re: **Geotechnical Response to Peer Review Comments**
 Proposed High-Rise Building
 1040 Somerset Street West - Ottawa

file: PG2674-MEMO.09

Paterson Group Inc. (Paterson) prepared the current memo to provide our responses to the geotechnical peer review comments in the letter entitled “Peer-Review of Geotechnical Report and Shoring Plans” prepared by DST Consulting Engineers Inc. (DST) and dated June 14, 2021. This memo should be read in conjunction with the current Geotechnical Investigation Report (Paterson Group Report PG2674-2 Revision 3 dated August 12, 2021).

WEST
STREET
SOMERSET

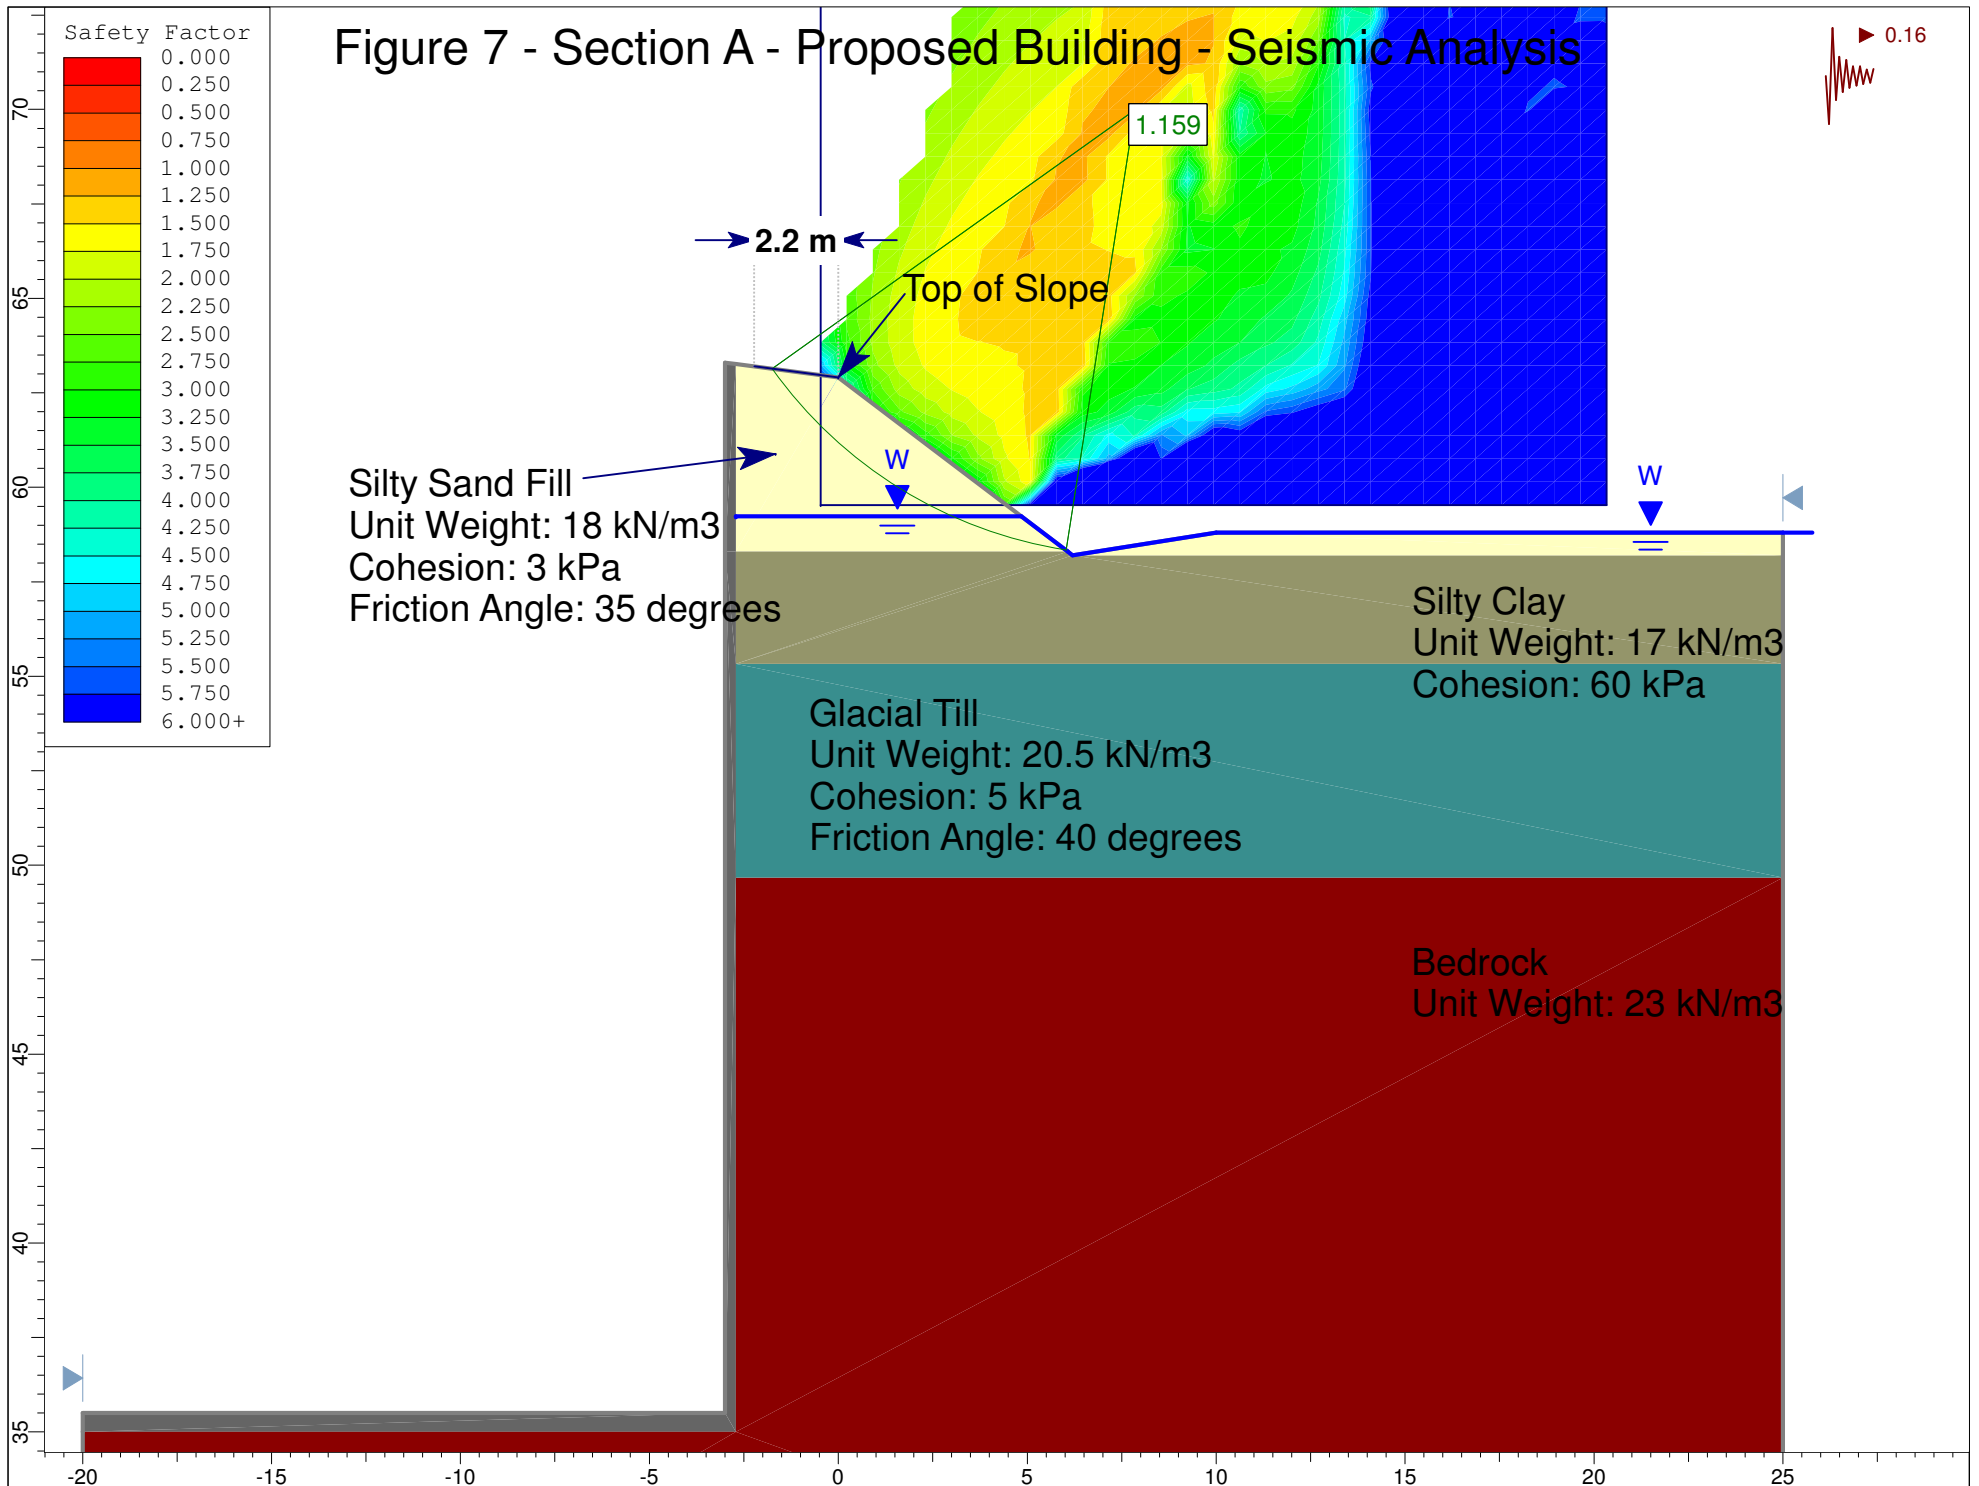
Comment 5: *The report includes slope stability evaluations under both static and seismic conditions for the west slope of the O-Train corridor indicating only a marginal safety factor against potential instability under the static condition. More detailed evaluation of the impact of the proposed construction methodology such as proposed dewatering, installation of sheet piles and tie backs, and equipment travel or operation on the stability of the existing and proposed slopes is therefore recommended.*

Response: For the permanent condition, once construction has been completed, the proposed development will not induce new loads on the existing slope, as the new walkway along the eastern boundary of the site will be cantilevered over the slope.

For the temporary condition during construction, dewatering is not expected due to the use of steel sheet piles as the temporary shoring system along the east side of the excavation. However, even in the event that some dewatering was to occur during the construction period, this would only act to improve the factor of safety of the slope.

Other construction activities such as sheet pile installations, tieback installations, and equipment travel are not expected to negatively affect the existing slope stability.
